HAYES STRUCTURAL

Date: May 15, 2025

Re: 23-KAHD-002.1.3
Fastener Deviation
Fleming Residence
354 Pointer Creek Drive
Angier, NC 27501

S-4

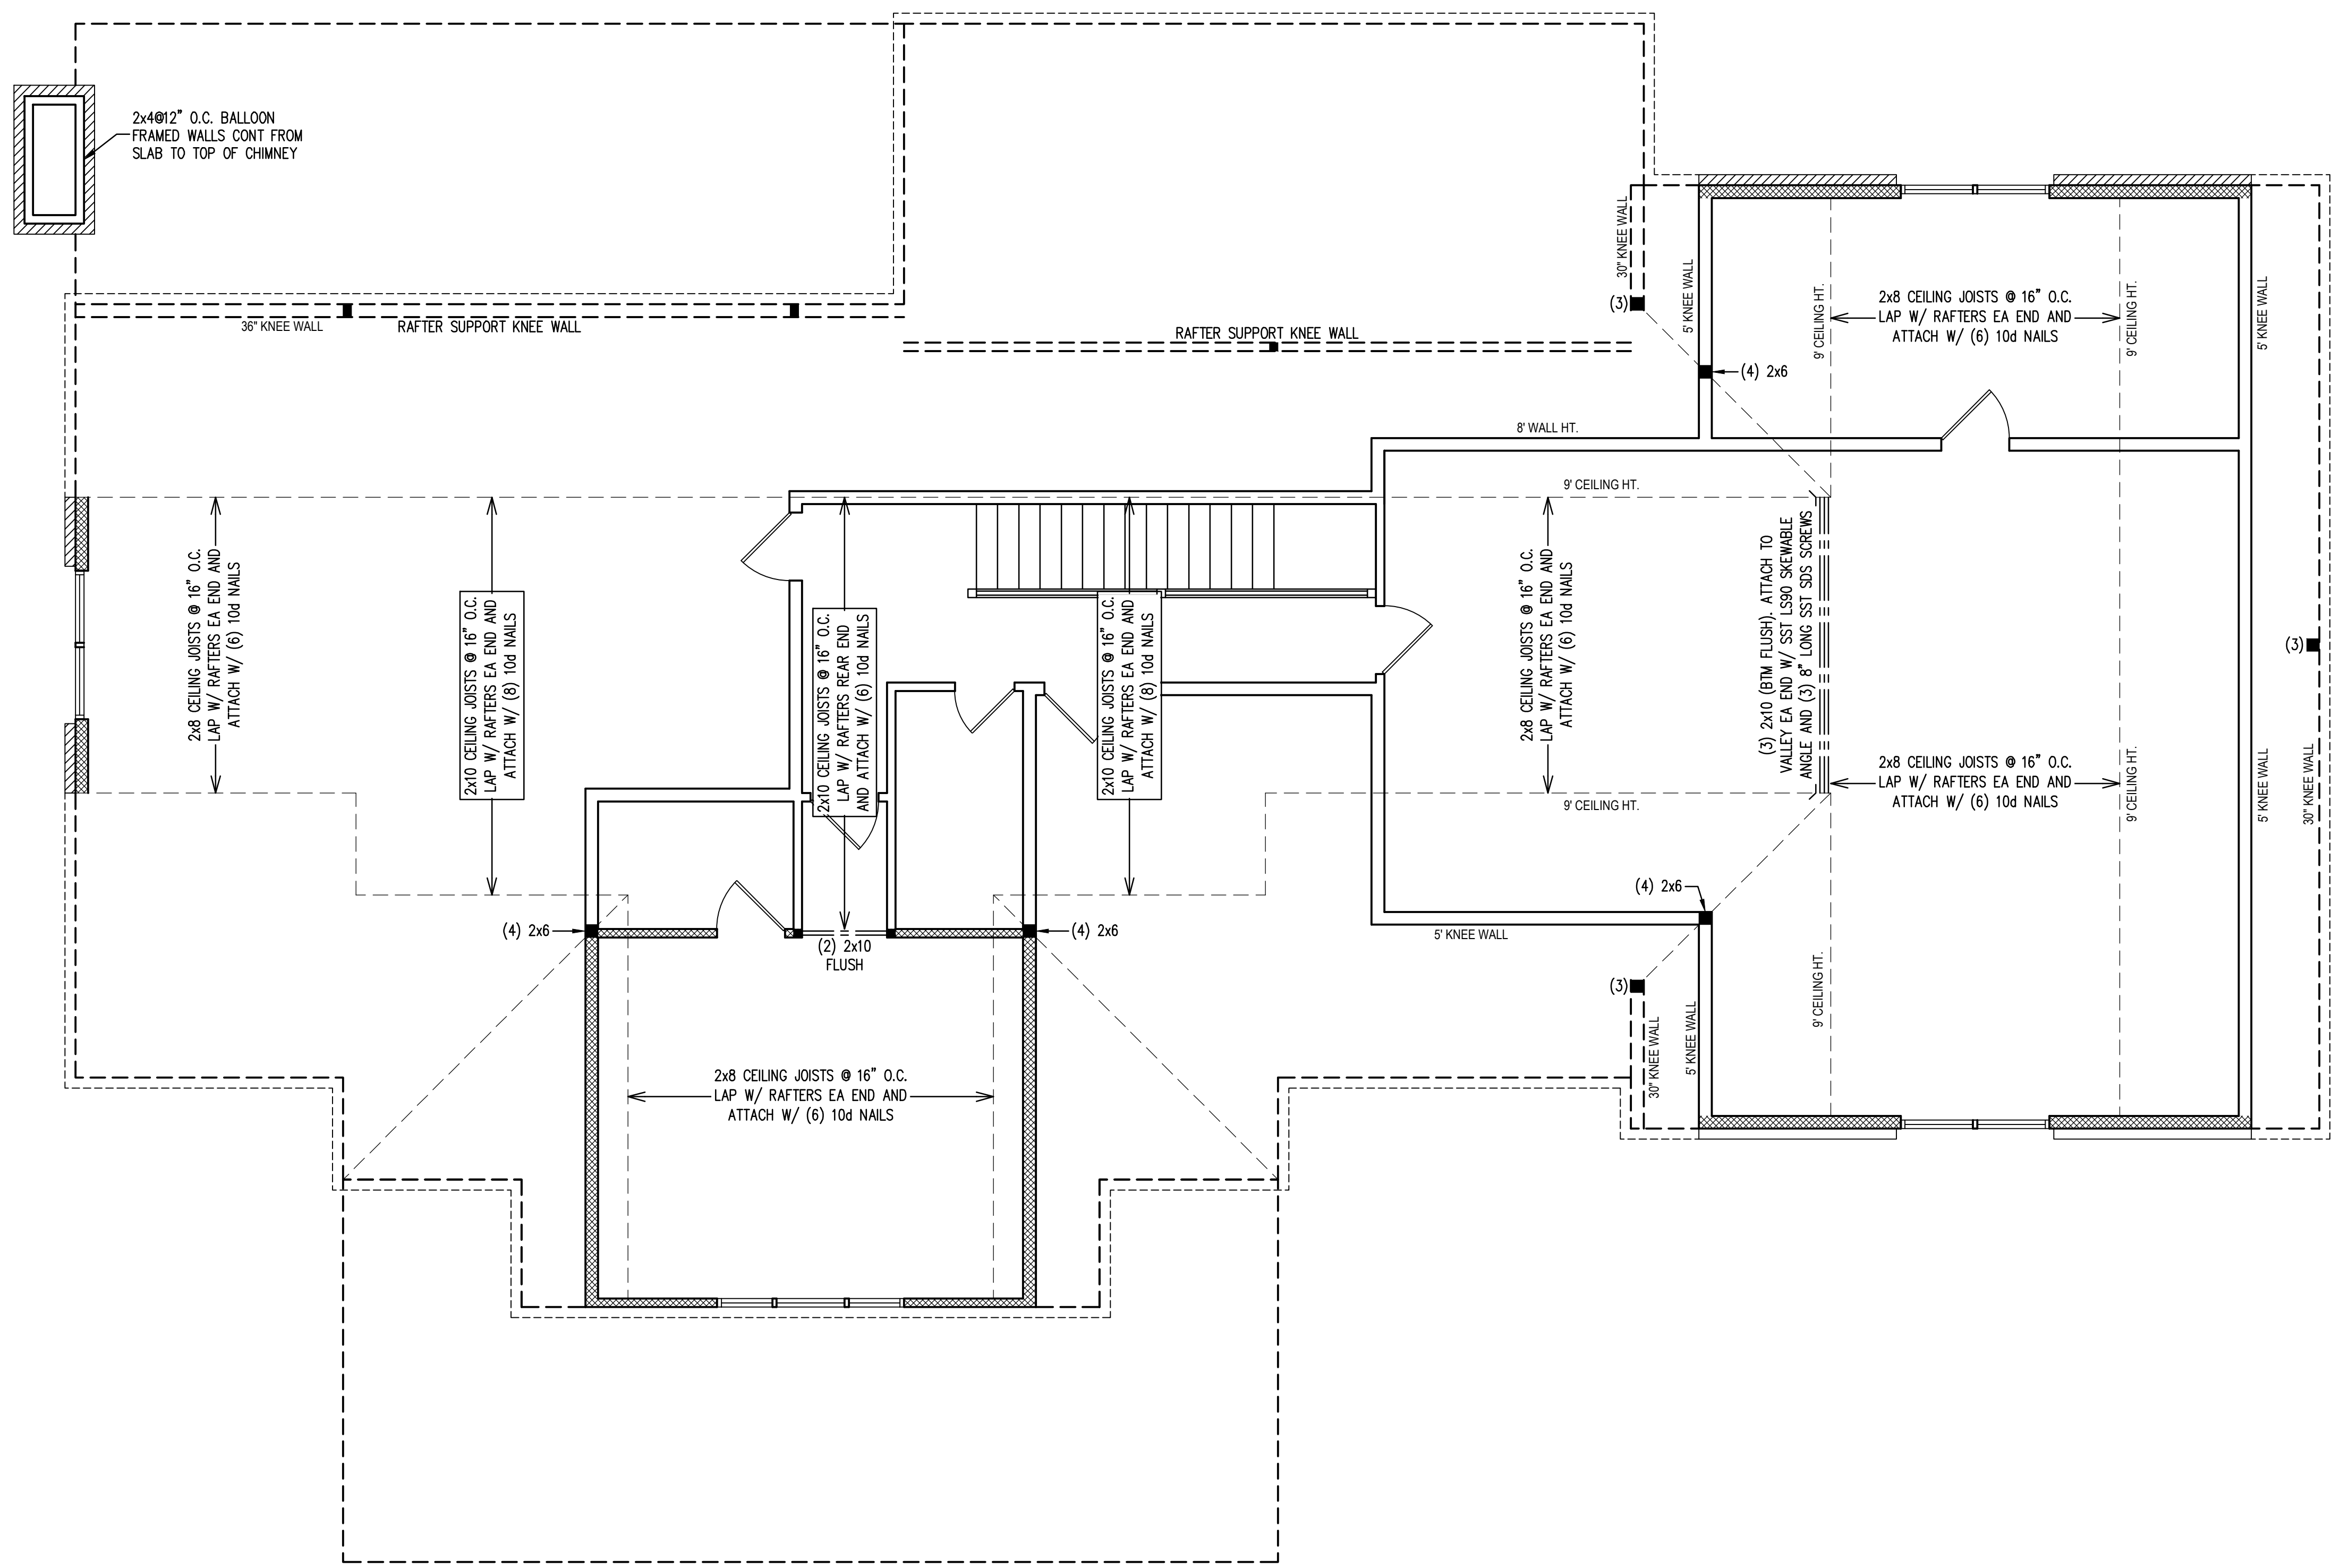
At your request, the plans and provided information were reviewed for the above referenced single family residence under construction to address the fastening of the (6) 1 $\frac{3}{4}$ "x24" LVL beam above the garage.

You indicated the (6) 1 $\frac{3}{4}$ "x24" LVL beam above the garage was fastened with (3) aligned rows of $\frac{1}{2}$ " diameter carriage bolts spaced 16" o.c. in lieu of staggering the bolts per plan. Additionally, you indicated the outer plies were bored in order to countersink the nuts and washers.

Analysis revealed the "as-built" (6) 1 $\frac{3}{4}$ "x24" LVL beam fastened with (3) aligned rows of $\frac{1}{2}$ " diameter carriage bolts spaced 16" o.c. countersunk into the outer plies is adequate and will provide the required support for all imposed loads. No structural modifications are required.
